SUMMARY OF KEY MODIFICATIONS AND REFINEMENTS

Design Modifications to SSD-66876472
Berrima Hotel

The following table provides a summary of design modifications that have been implemented, in response to matters raised by DPHI and the Wingecarribee Shire Council dated 26th November 2025.

Lower Basement

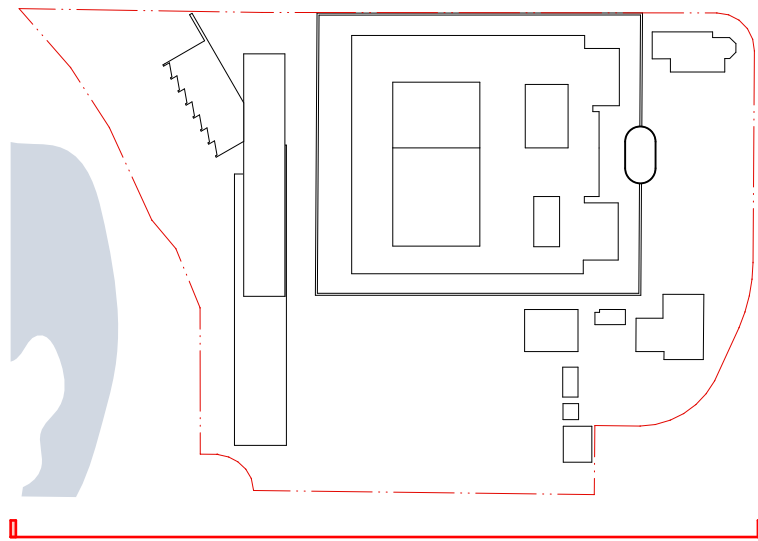
2	Implementation of additional flood mitigation measures Item 6: Flood Impact Assessment <i>"Department has concerns in relation to the basement carpark design and requires additional assessment in relation to best practice basement flood -mitigation measures . Address comments/recommendations in advice from Council, DCCEEW CPHR and SES regarding flood emergency evacuation response and basement carpark design."</i>	The design proposal has been updated to address the technical requirements outlined by Martens Environmental Science and Engineering Consultants, in response to the concerns raised by DPHI. The proposed modifications include - Addition of flood doors to prevent inflows into the basement Flood doors have been added to the HW Plant, service rooms, Store Rooms, Generator room and Fire Stair FS3 in the basement to prevent inflows into the basement.	DA-110-006 Lower Basement DA-210-301 South Elevation

3	Implementation of additional flood mitigation measures Item 6: Flood Impact Assessment <i>"Department has concerns in relation to the basement carpark design and requires additional assessment in relation to best practice basement flood -mitigation measures . Address comments/recommendations in advice from Council, DCCEEW CPHR and SES regarding flood emergency evacuation response and basement carpark design."</i>	The design proposal has been updated to address the technical requirements outlined by Martens Environmental Science and Engineering Consultants, in response to the concerns raised by DPHI. The proposed modifications include - Amended arrangement to the services rooms within the basement Walls have been removed between the HW Plant and Service room and between the Generator Room and the Tank room to work with the overall flood mitigation strategy and feedback from the flood consultant.	DA-110-006 Lower Basement

4	Implementation of additional flood mitigation measures Item 6: Flood Impact Assessment <i>"Department has concerns in relation to the basement carpark design and requires additional assessment in relation to best practice basement flood -mitigation measures . Address comments/recommendations in advice from Council, DCCEEW CPHR and SES regarding flood emergency evacuation response and basement carpark design."</i>	The design proposal has been updated to address the technical requirements outlined by Martens Environmental Science and Engineering Consultants, in response to the concerns raised by DPHI. The proposed modifications include - Louvres to the western façade of the Store and Linen room removed The louvres have been removed to the Store and Linen room, and replaced with a solid wall (CLD1c), to respond to the overall flood mitigation strategy and feedback from the flood consultant.	DA-110-006 Lower Basement DA-210-401 Wingecarribee River East Elevation

Status	Project No.	Rev
For Information	23014	C
Scale	Dwg No.	
1:250 @ B1	DA-210-301

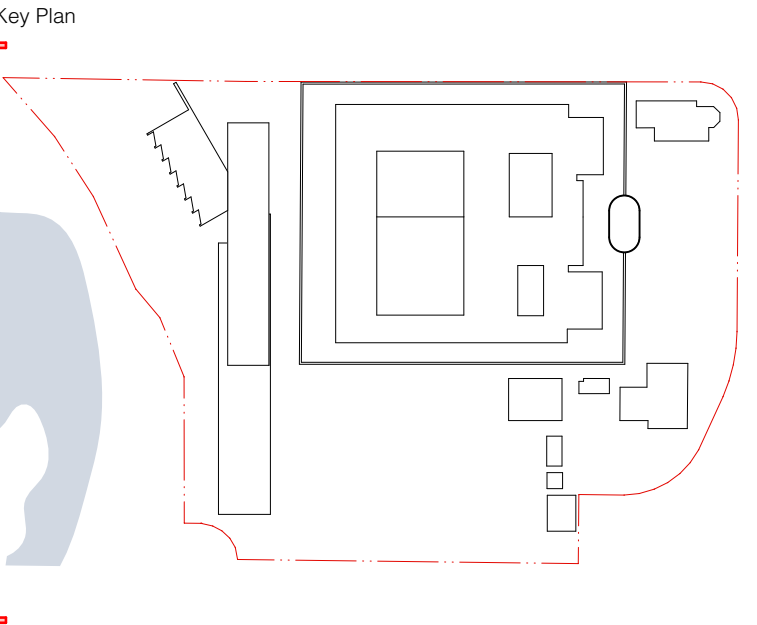
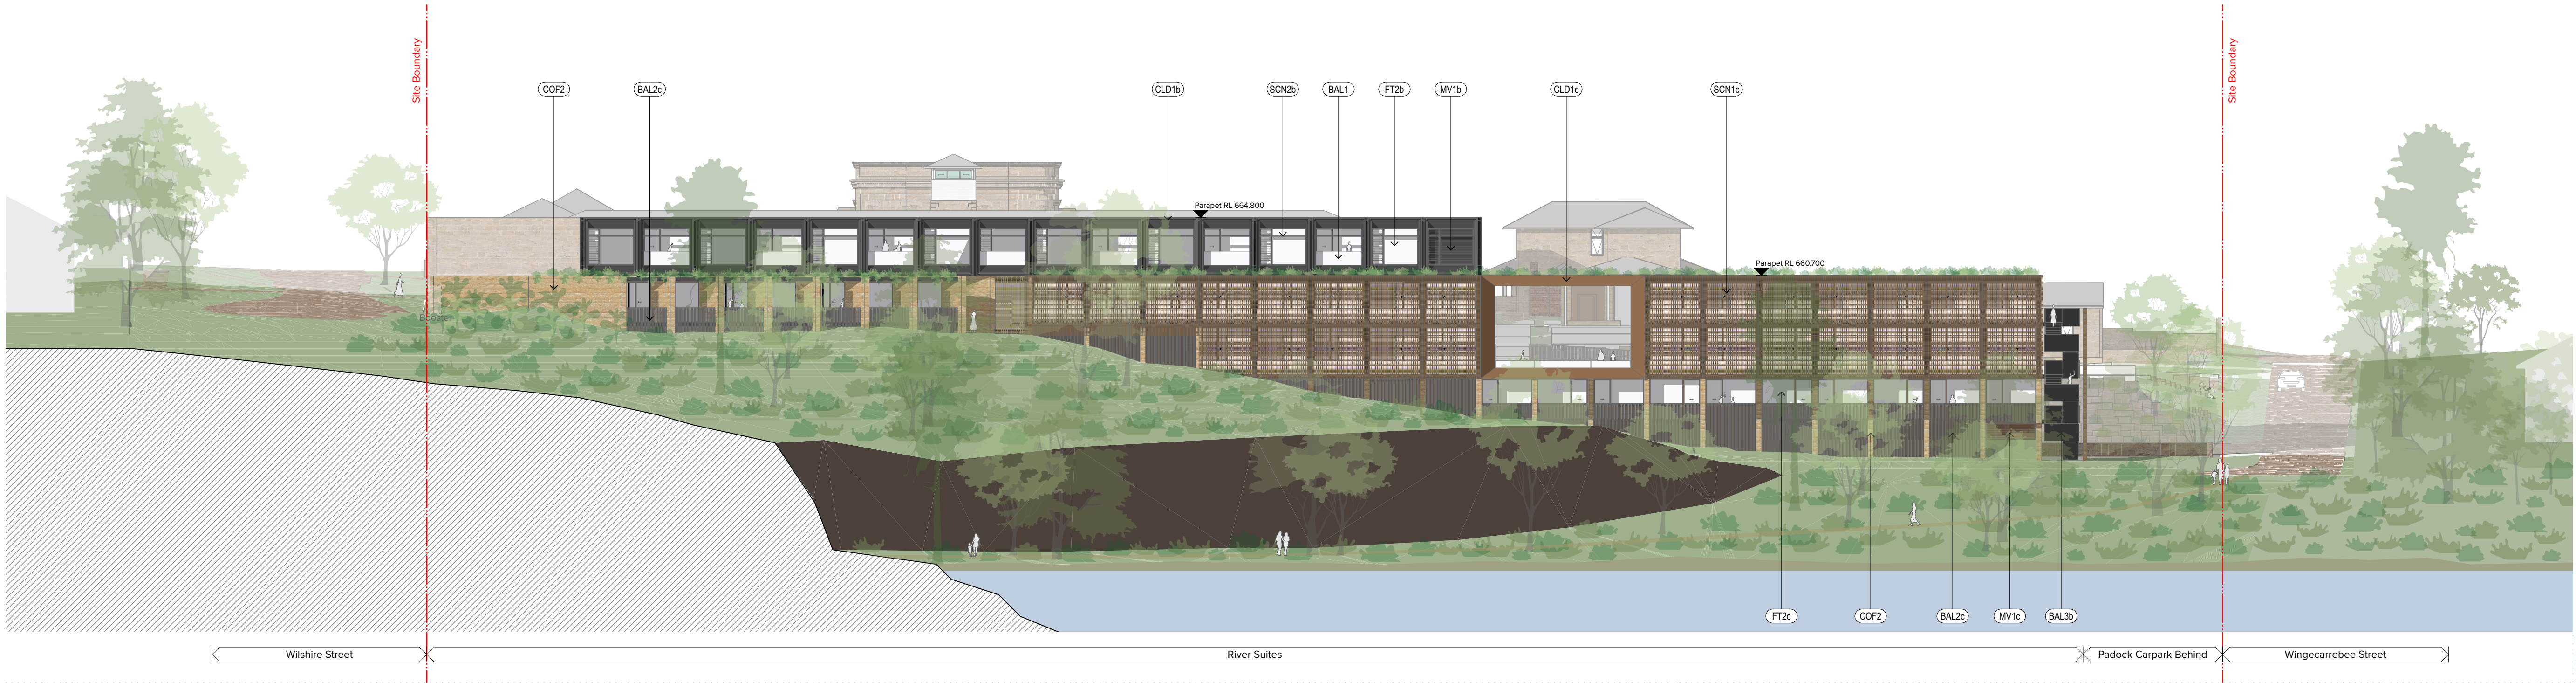
Summary of Amendments			
Change No.	Reason for Refinement	Description	Drawing Reference
1	Implementation of additional flood mitigation measures Item 6: Flood Impact Assessment <i>"Department has concerns in relation to the basement carpark design and requires additional assessment in relation to best practice basement flood -mitigation measures . Address comments/recommendations in advice from Council, DCCEEW CPHR and SES regarding flood emergency evacuation response and basement carpark design."</i>	The design proposal has been updated to address the technical requirements outlined by Martens Environmental Science and Engineering Consultants, in response to the concerns raised by DPHI. The proposed modifications include - Flood Gate Barrier Integration of a flood gate barrier to the top of the ramp to protect the basements to RL 649.00 AD Modification to height of walls to side of ramp: The height of the walls running along the basement ramp have been increased to respond to the requirements outlined in the flood protection measures, to RL 649.00 AD	DA-110-006 Lower Basement DA-110-007 Upper Basement DA-110-008 Lower Ground_Upper Escarpment DA-110-009 Ground Level DA-110-010 Level 1_Gaol DA-110-020_Roof Level DA-210-301 South Elevation DA-220-501 West Elevation - Secret Door DA-220-601 East Elevation – Hotel Suites

Scale	Dwg No.
1:250 @ B1	DA-310-401

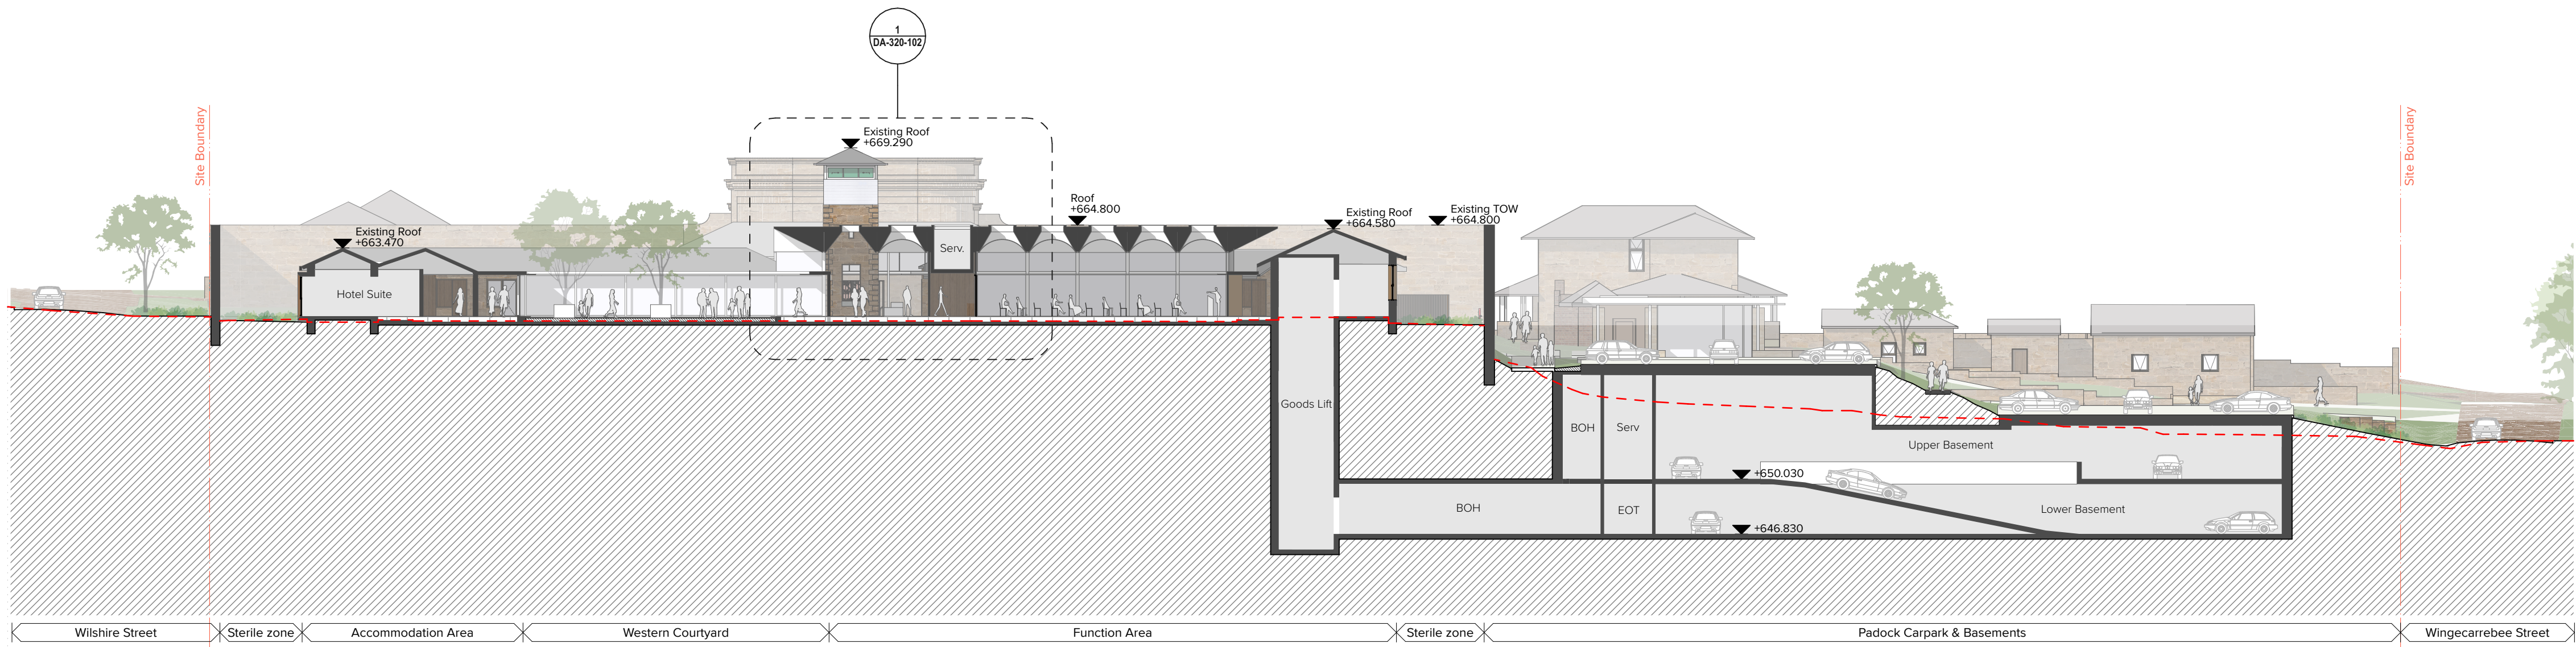
Summary of Amendments			
Change No.	Reason for Refinement	Description	Drawing Reference
5	Implementation of additional flood mitigation measures Item 6: Flood Impact Assessment <i>"Department has concerns in relation to the basement carpark design and requires additional assessment in relation to best practice basement flood -mitigation measures . Address comments/recommendations in advice from Council, DCCEEW CPHR and SES regarding flood emergency evacuation response and basement carpark design."</i>	The design proposal has been updated to address the technical requirements outlined by Martens Environmental Science and Engineering Consultants, in response to the concerns raised by DPHI. The proposed modifications include - Additional height provided to kerb to the sections of the perimeter of the at-grade carpark 150mm height kerb has been integrated into the at-grade carpark design along the rear of the substation	DA-110-009 Ground Level DA-110-010 Level 1_Gaol DA-110-020_Roof Level DA-210-301 South Elevation DA-210-401 Wingecarribee River East Elevation DA-220-501 West Elevation - Secret Door DA-310-401 Section DD
